Administrative Authorization Application

PROJECT NAME: RIVERTON PARK HOUSING 2013-095
 PROJECT ADDRESS: 2 RIVERTON DRIVE CHART/BLOCK/LOT: 3 27 B012
 APPLICATION FEE: 50 (\$50.00)
 PROJECT DESCRIPTION: (Please Attach Sketch/Plan of the Proposal/Development)
12' X 12' SALT SHED

Administrative Authorization Decision

Application #: 2013-095
Name: Riverton Park Salt Shed
Address: RIVERTON DR
Description: 12' x 12' Salt Shed

RIVERTON PARK HOUSING
SALT SHED LOCATION
PORTLAND HOUSING AUTHORITY

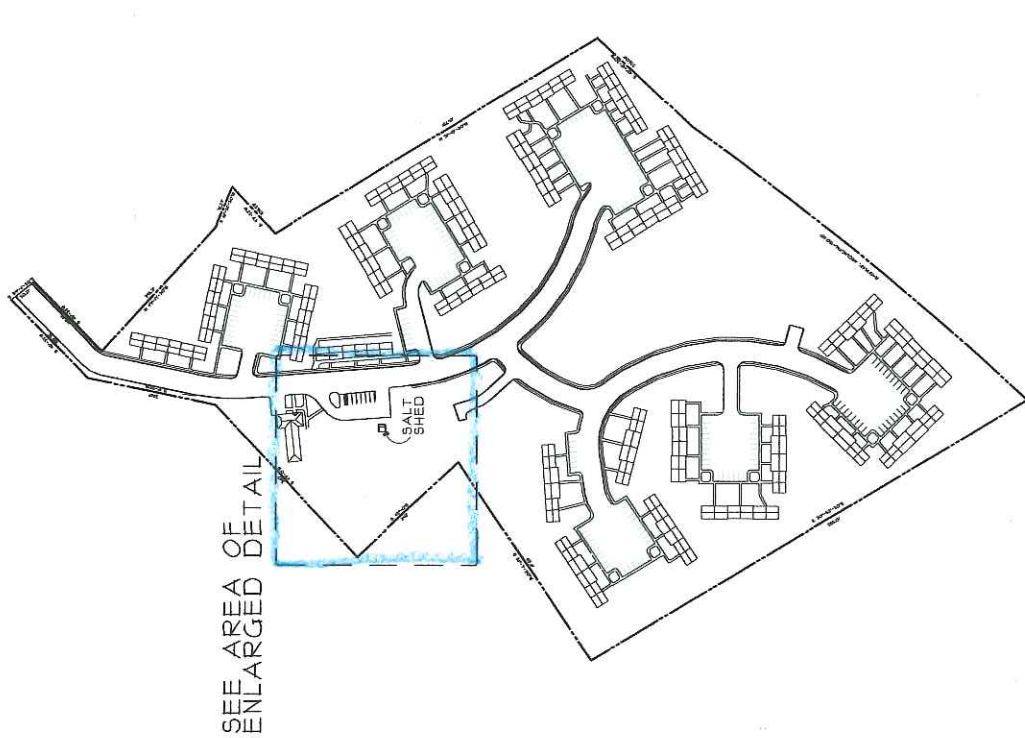
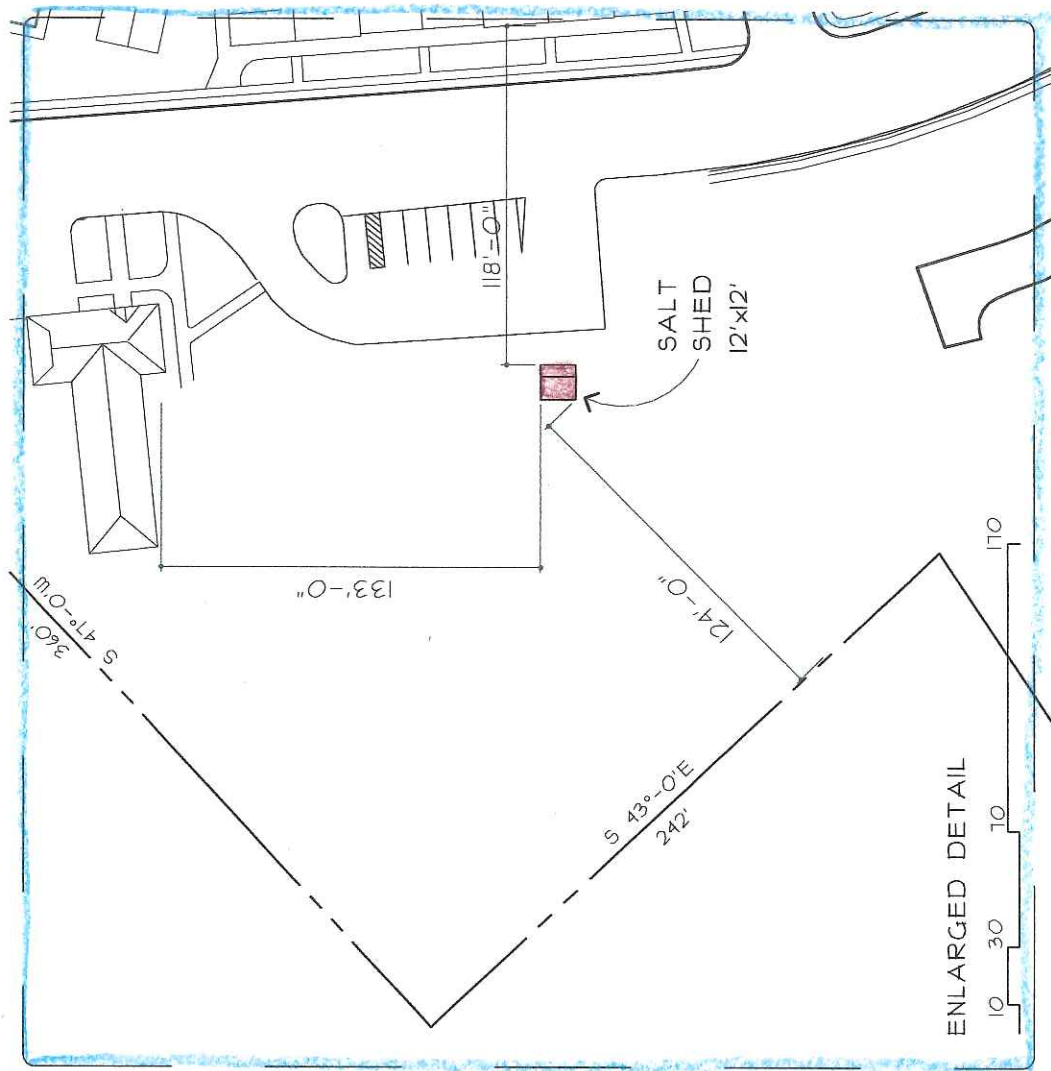
- 1) The Department of Public Services has the following comments in reference to the Sagamore Village & Riverton Park Salt/Sand Sheds.
 1. Place salt storage sheds on a paved pad. The storage pad should be pitch slightly forward the street to prevent any collection of water inside the shed. Care should be taken to avoid drainage from the surrounding area from entering the storage sheds.
 2. Salt shed should be covered and the cover should be maintained to prevent leaks.

1. Salt shed should not be overfilled so as to expose salt to the elements and where possible the entrance should be protected by doors, flaps or other means to keep out the elements
2. Care should be taken when transferring, loading or otherwise handling salt/sand to avoid spills. All spilled material should be cleaned up immediately and returned to the storage shed using dry methods (i.e.: Sweeping, shoveling, etc.). Do not overfill sanding/salting equipment.
3. Loading, handling and access areas should be kept clean and free of salt/sand and visually

inspected regularly during active operational period. These areas should be included in street sweeping routine.

4. Spring Cleaning: Never hose down or power wash spilled salt/sand from handling or access areas; Clean up materials using dry methods and/or a street sweeper.
